29/03/2022

Taronga Wildlife Hospital Nutrition Centre (SSD-17655146)

Response to Submissions

Drawing Number
AA-N1201

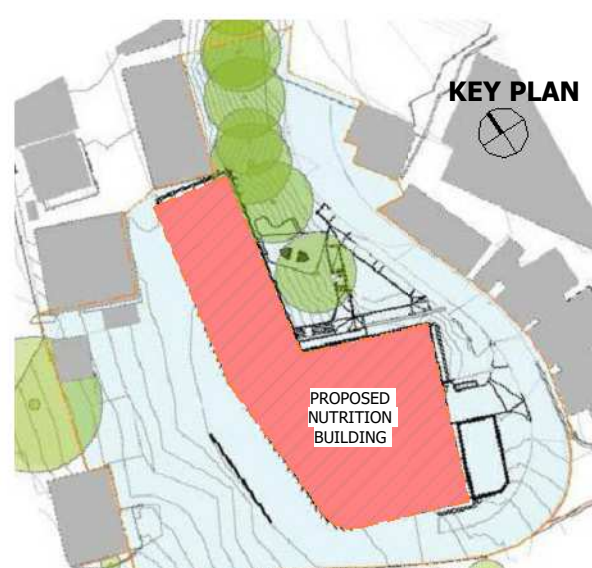
1. The architectural plans submitted provide two different revisions for the following plans:
 - General Arrangement for Level 2, drawing number AA-N1201 (Revision R and Revision S)
 - General Arrangement for Level 4, drawing number AA-N1203 (Revision Q and R)
 - General Arrangement Roof Plan, drawing number AA-N1204 (Revision R and S)

Please confirm the correct revisions for all plans above.

Drawing Number
AA-N1204

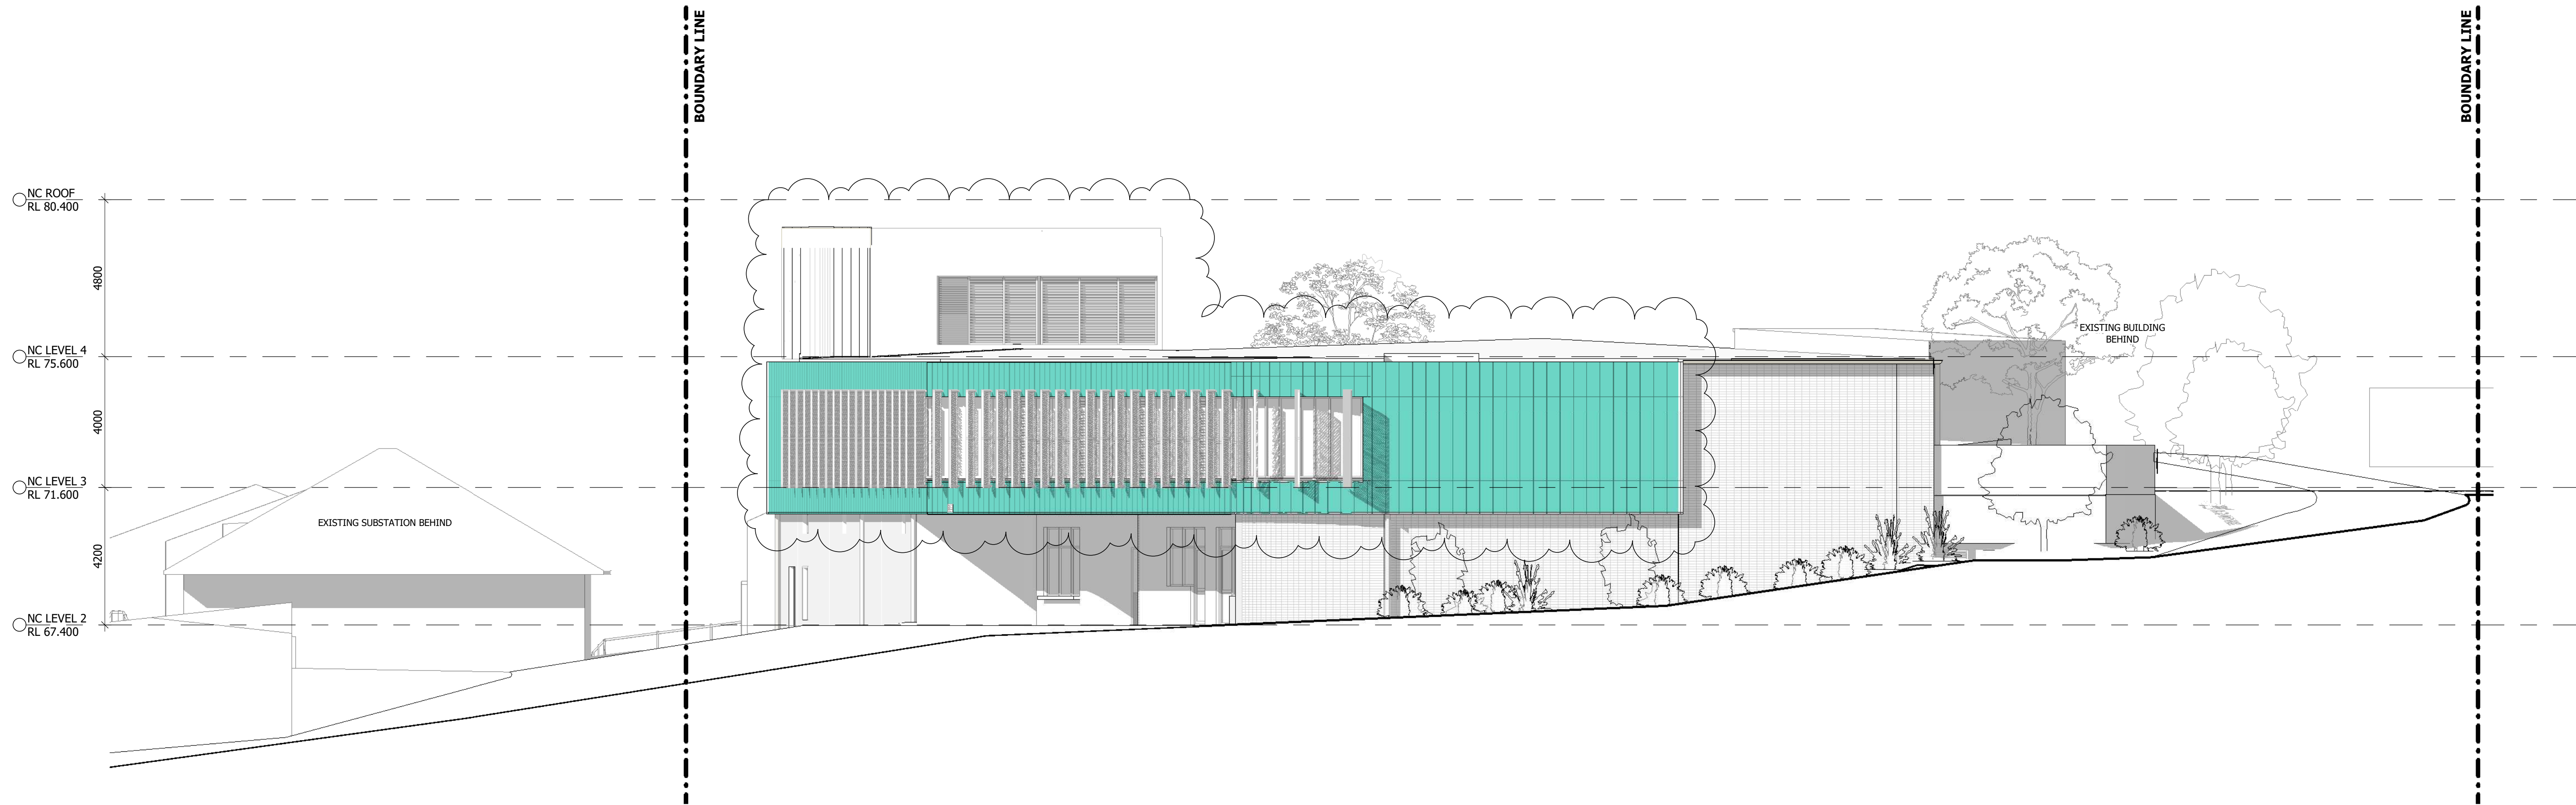
2. The bulk and scale including height of the rooftop plant appears excessive and dominates the building and should be reduced to provide a better relationship and integration between the building and plant.

AA-N2000

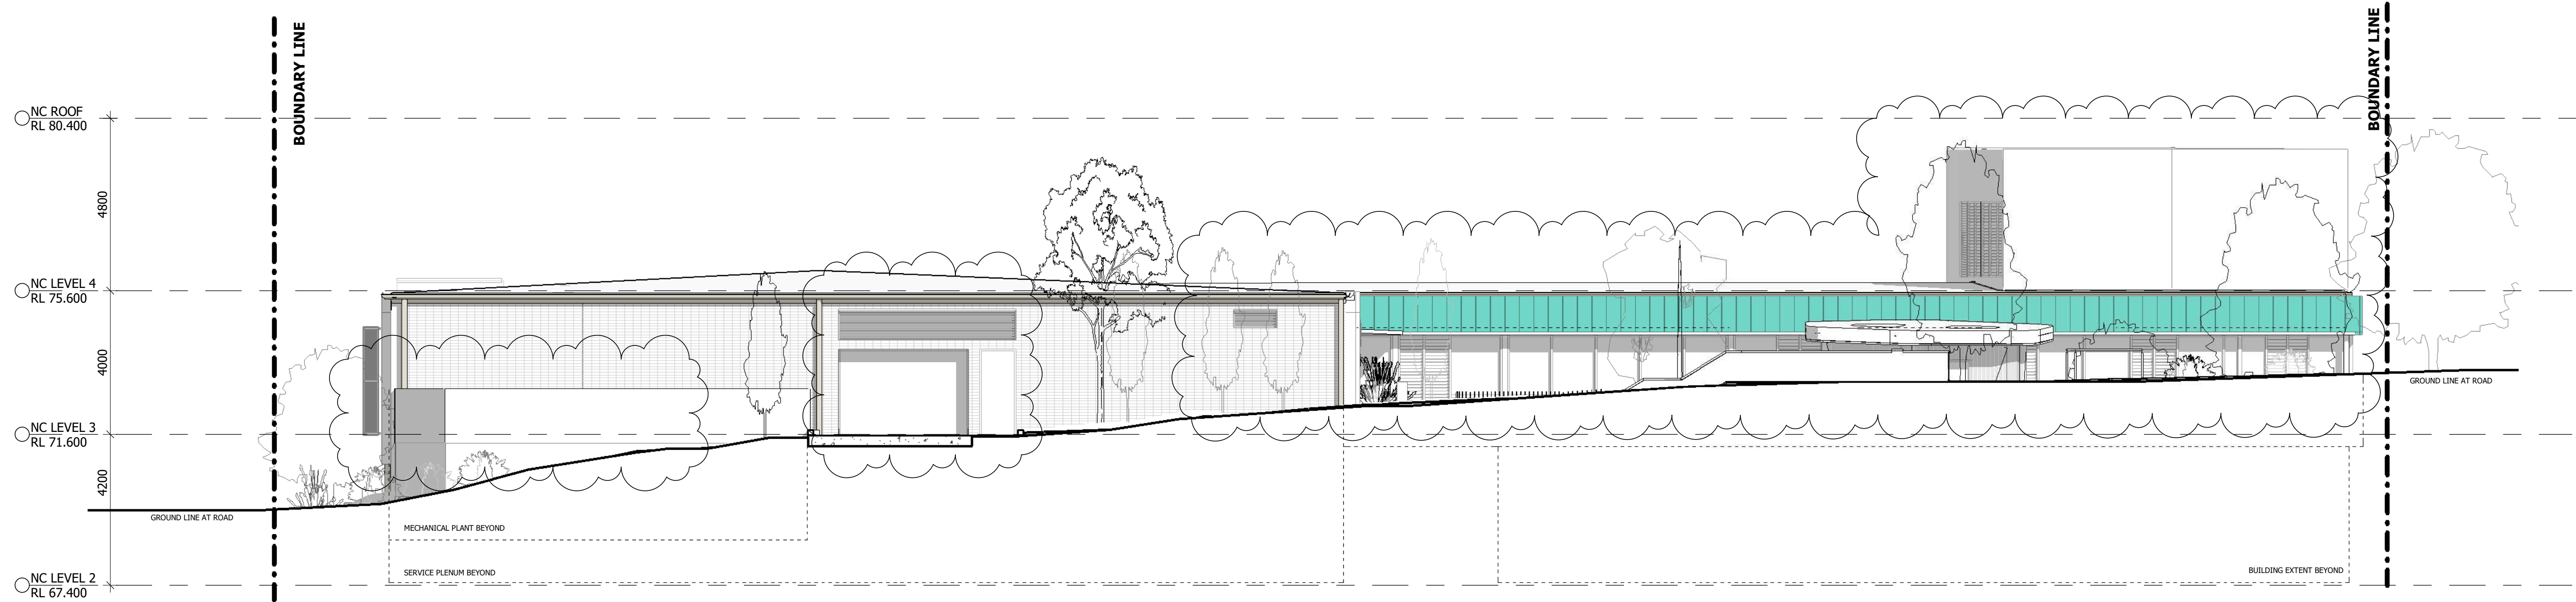
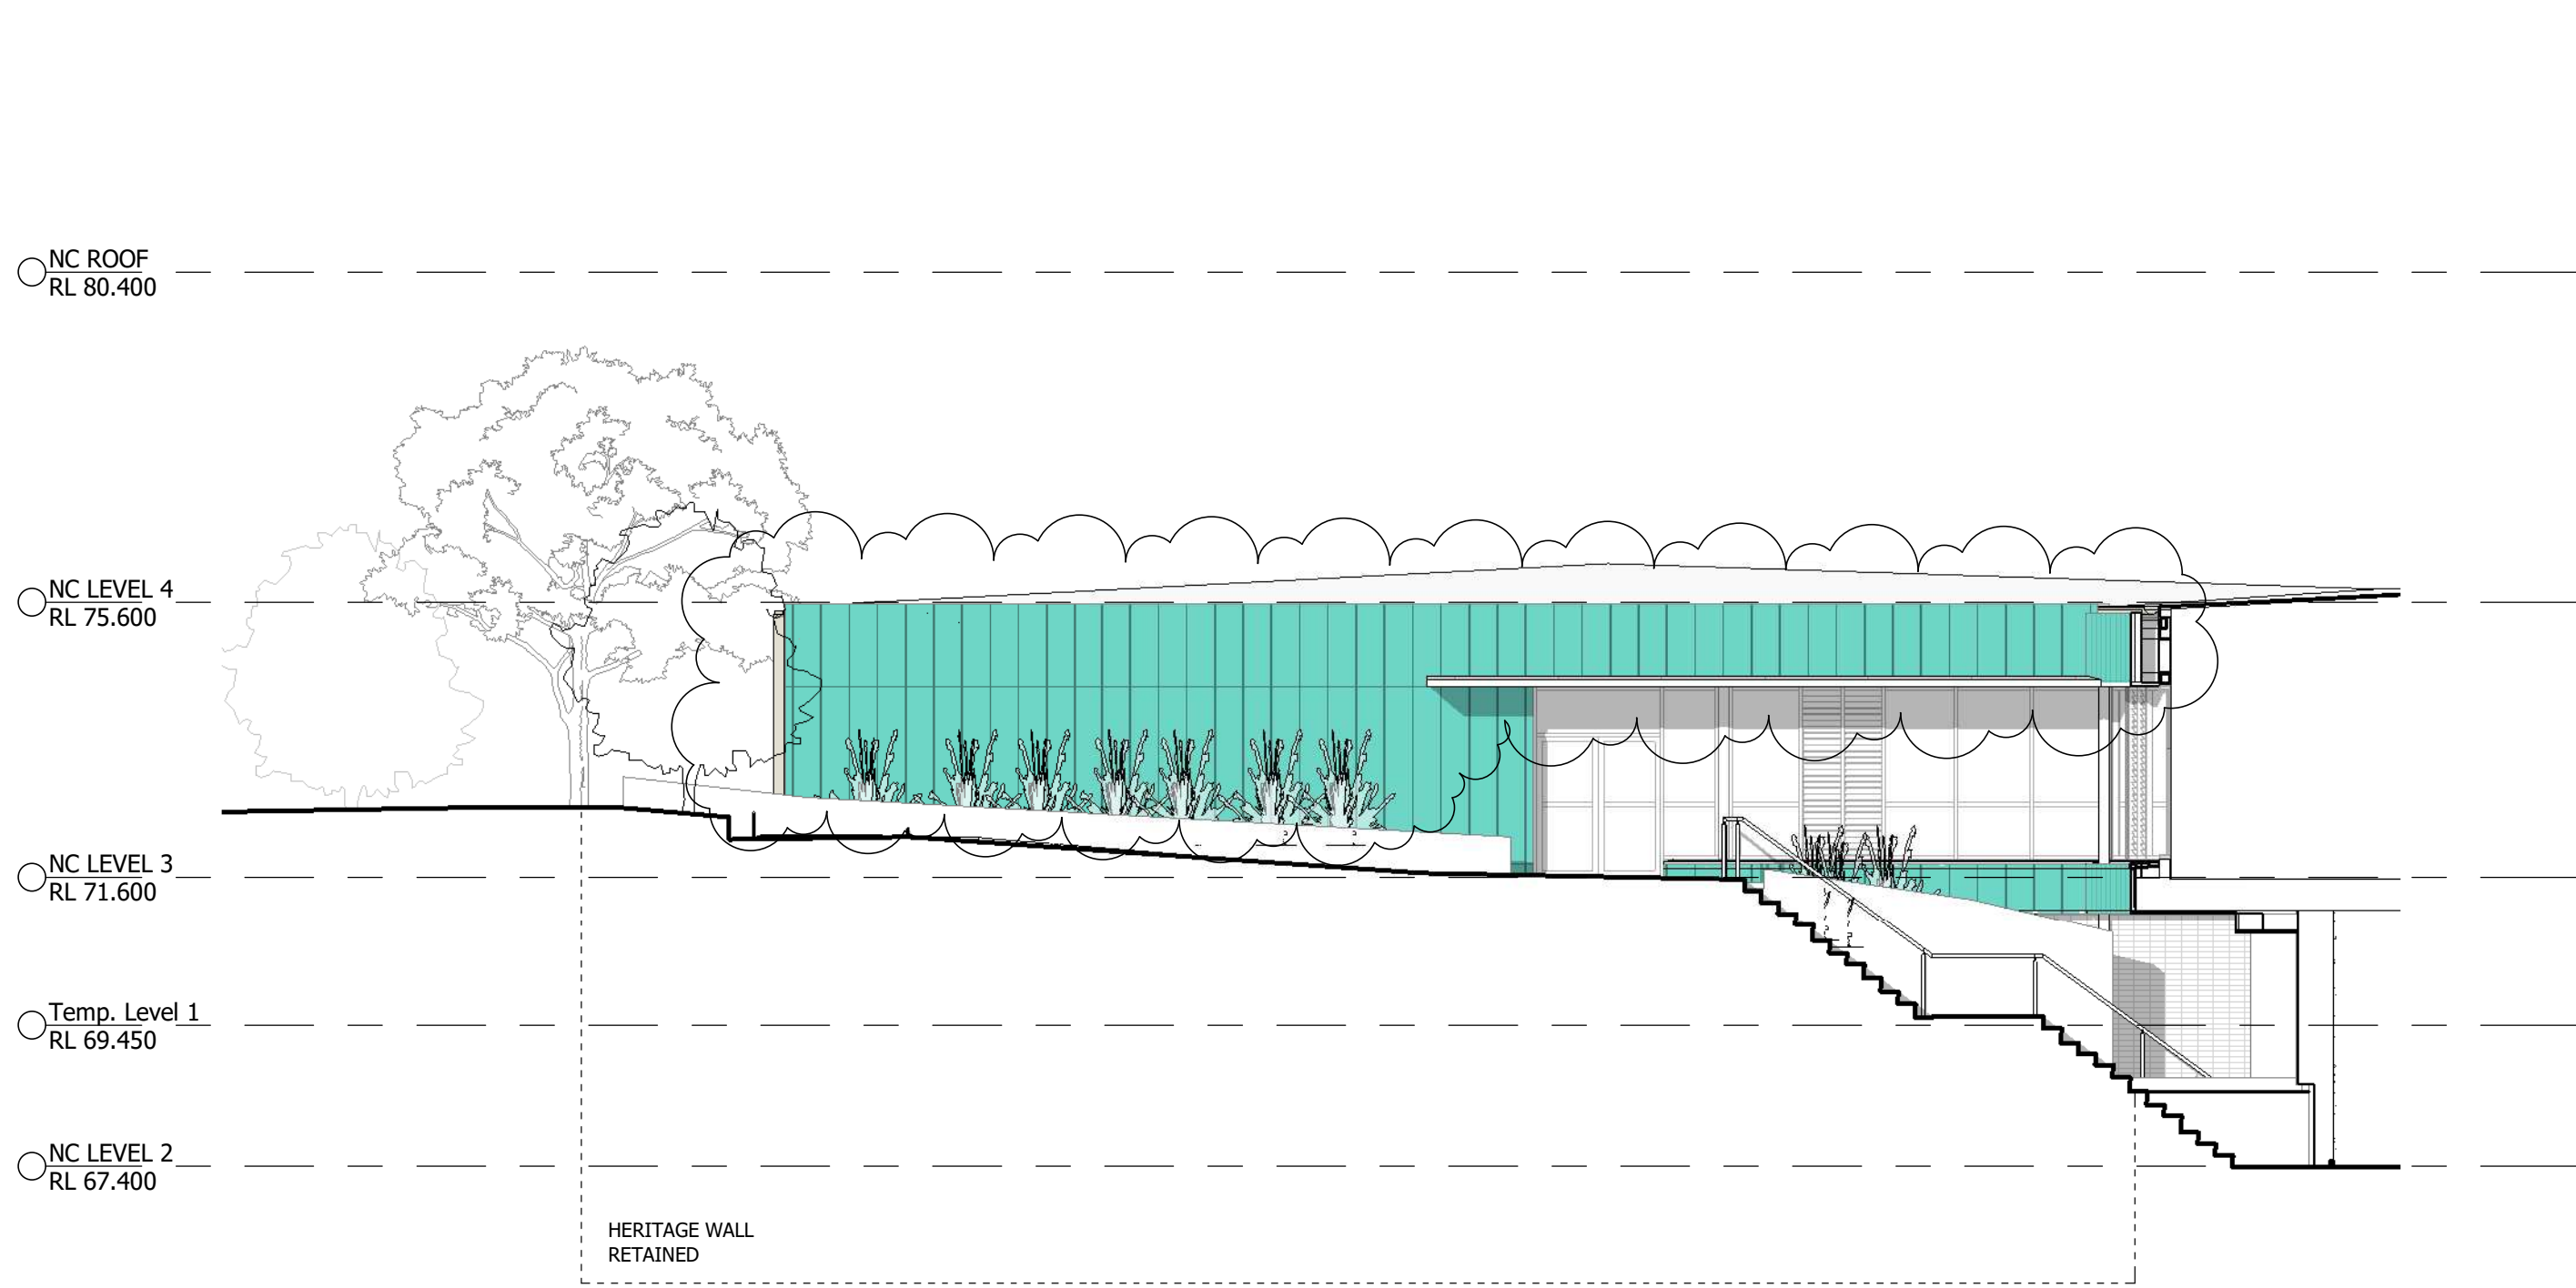
9. As stated in the EIS, signage is not to be assessed as part of the application. Elevation plans showing any proposed signage should omit signage.
